FAO: Planning Department,
Welwyn Hatfield Borough Council

Ref: 6/2017/2962/FULL
Date: 27/03/2018

HISTORIC BUILDINGS AND CONSERVATION ADVICE

RE: Rhodes Wood Hospital, Shepherds Way, Brookmans Park, Hatfield, AL9 6NN

Title
Proposed Elevations & Section

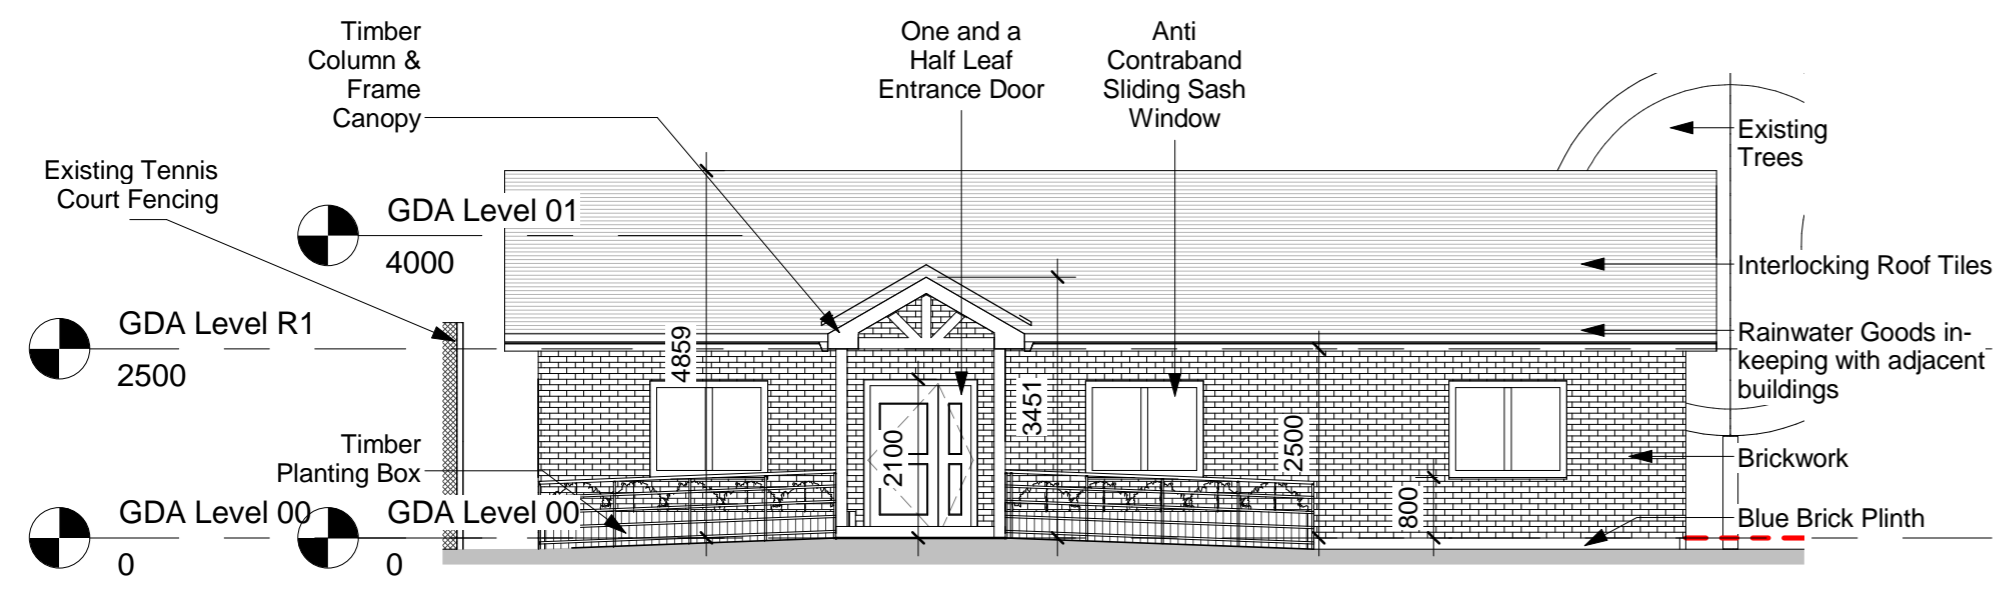
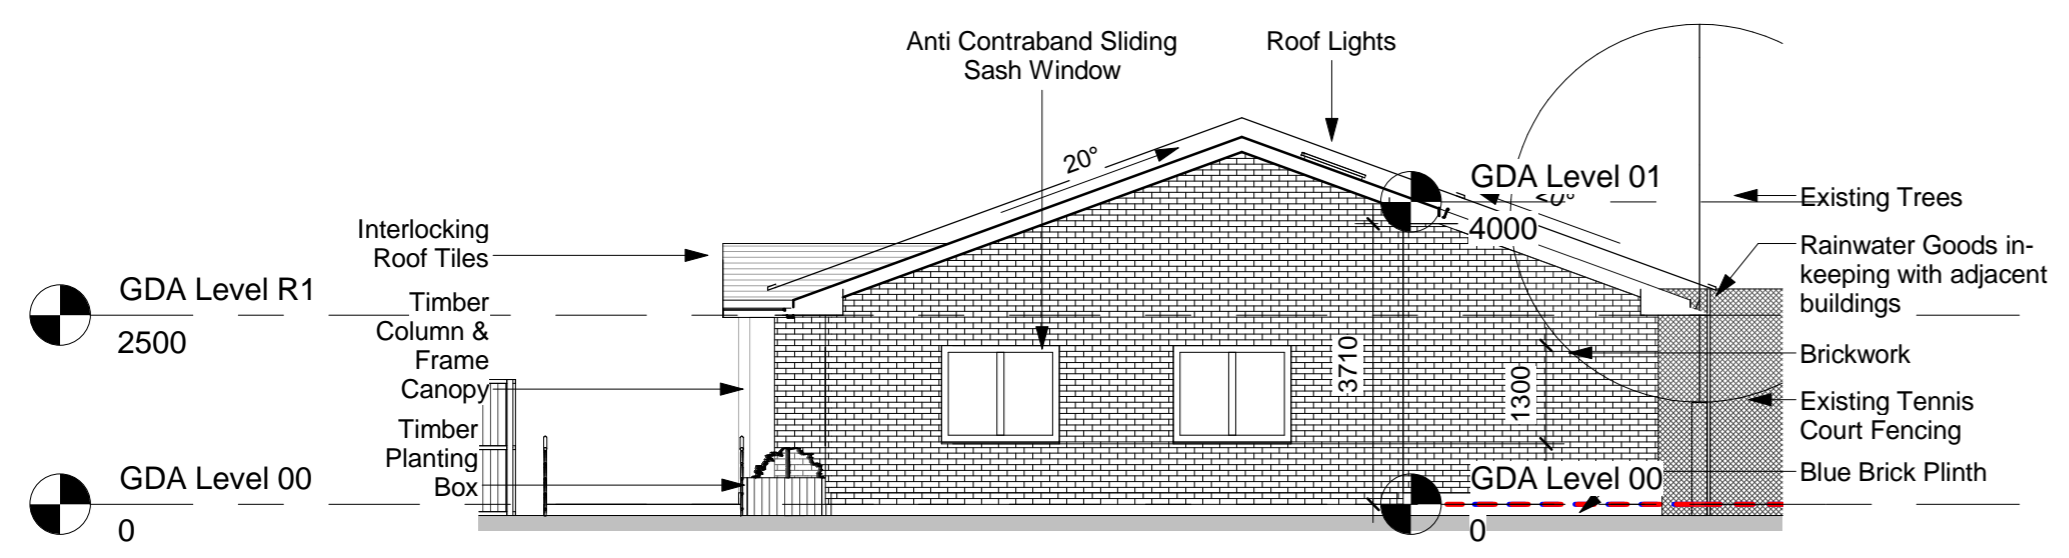
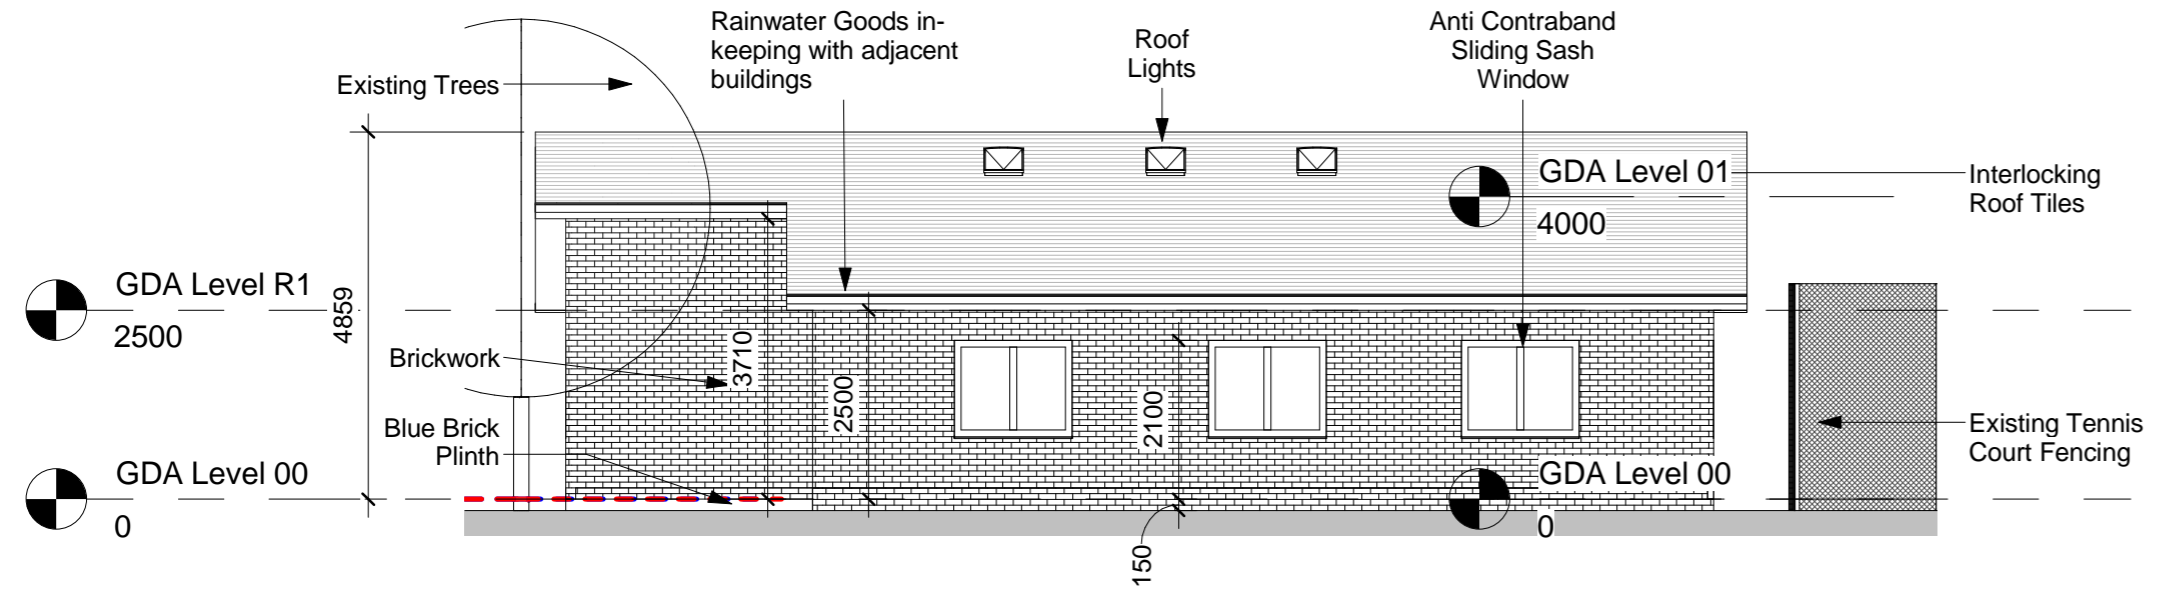
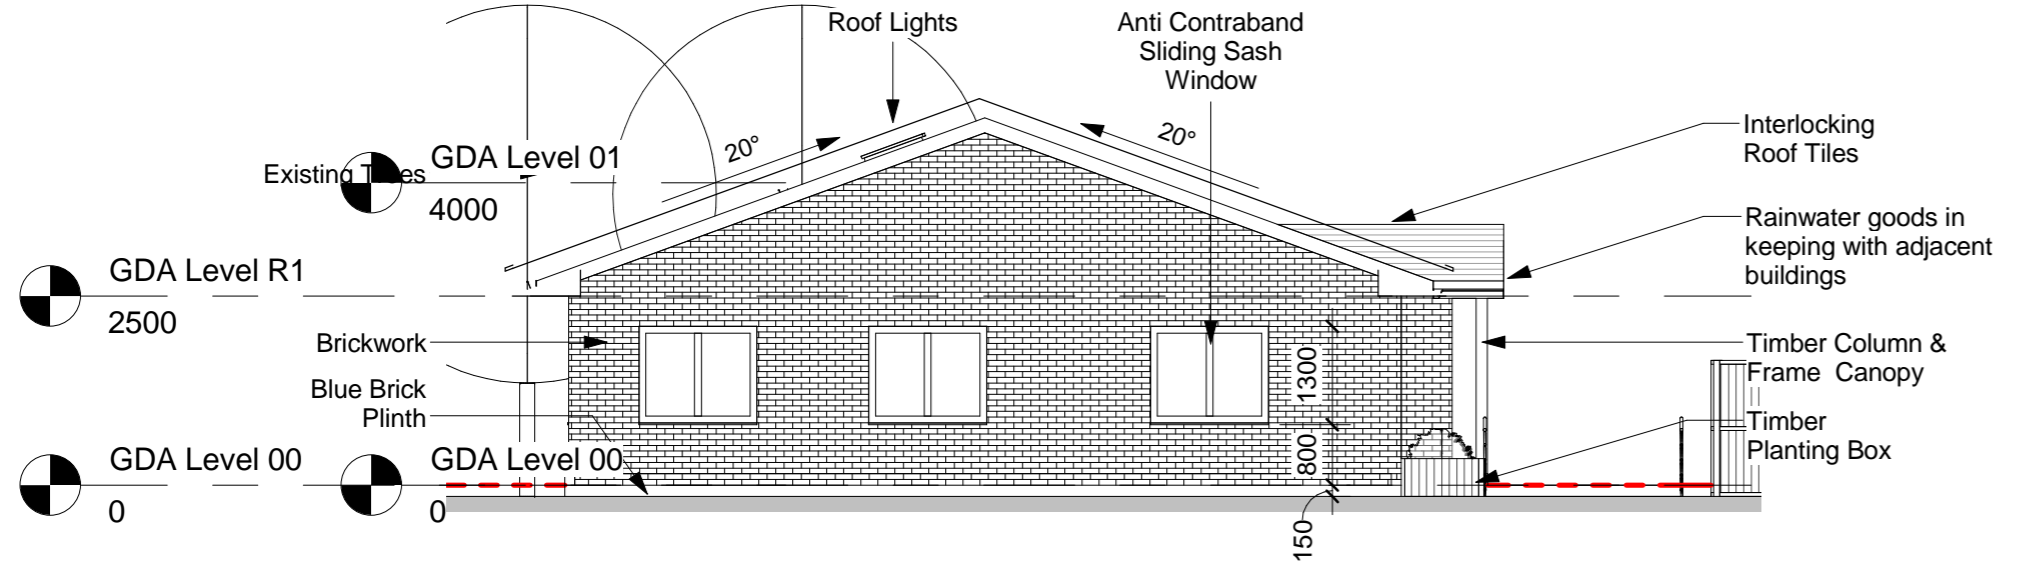
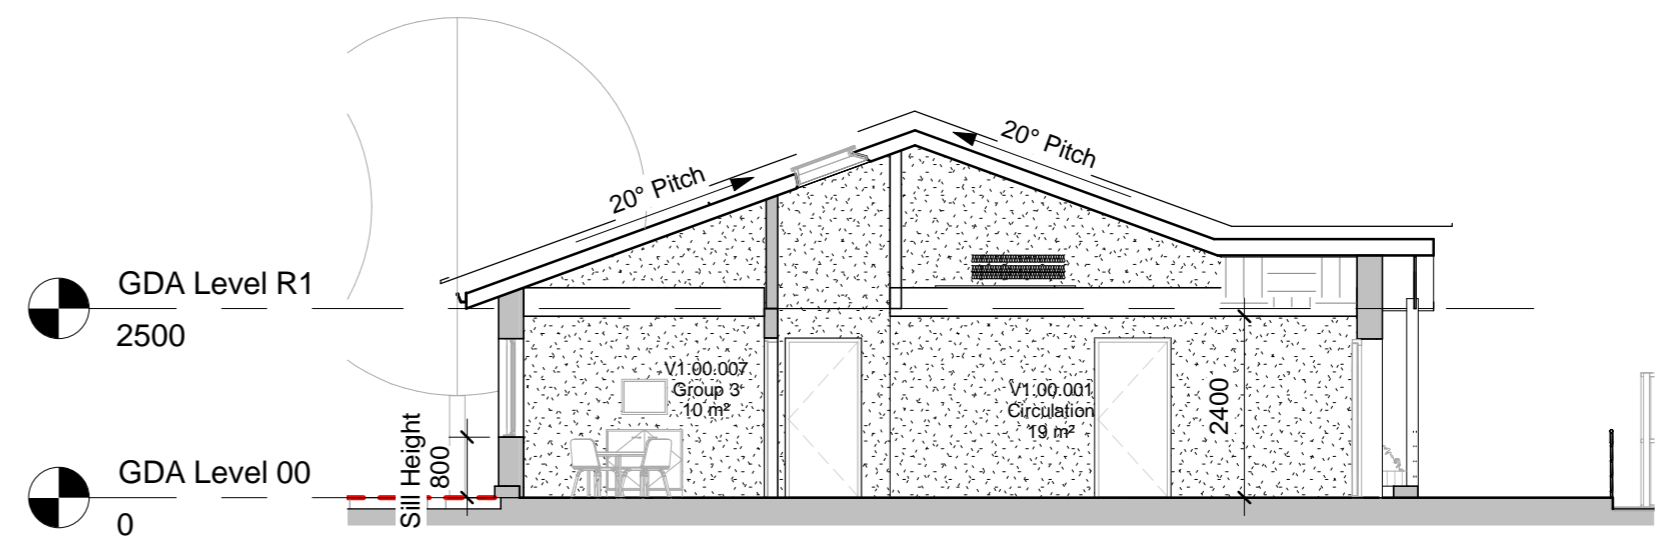
The initial consultation identified that the design and materiality of the proposed single storey building would detract from the significance of the listed building. The materials for the proposed building have now been amended to be brick to match those of the existing adjacent brick extension. It is considered that the amended materiality would be sympathetic to the listed building and I therefore have no further concerns regarding the proposed single storey building.

Overall, it is considered that the proposed single storey building would cause harm to the significance of Mymwood School due to change within its setting. This harm is however considered to be minimal and towards the lower end of the scale of less than substantial and would have to be weighed against the public benefits of the scheme.
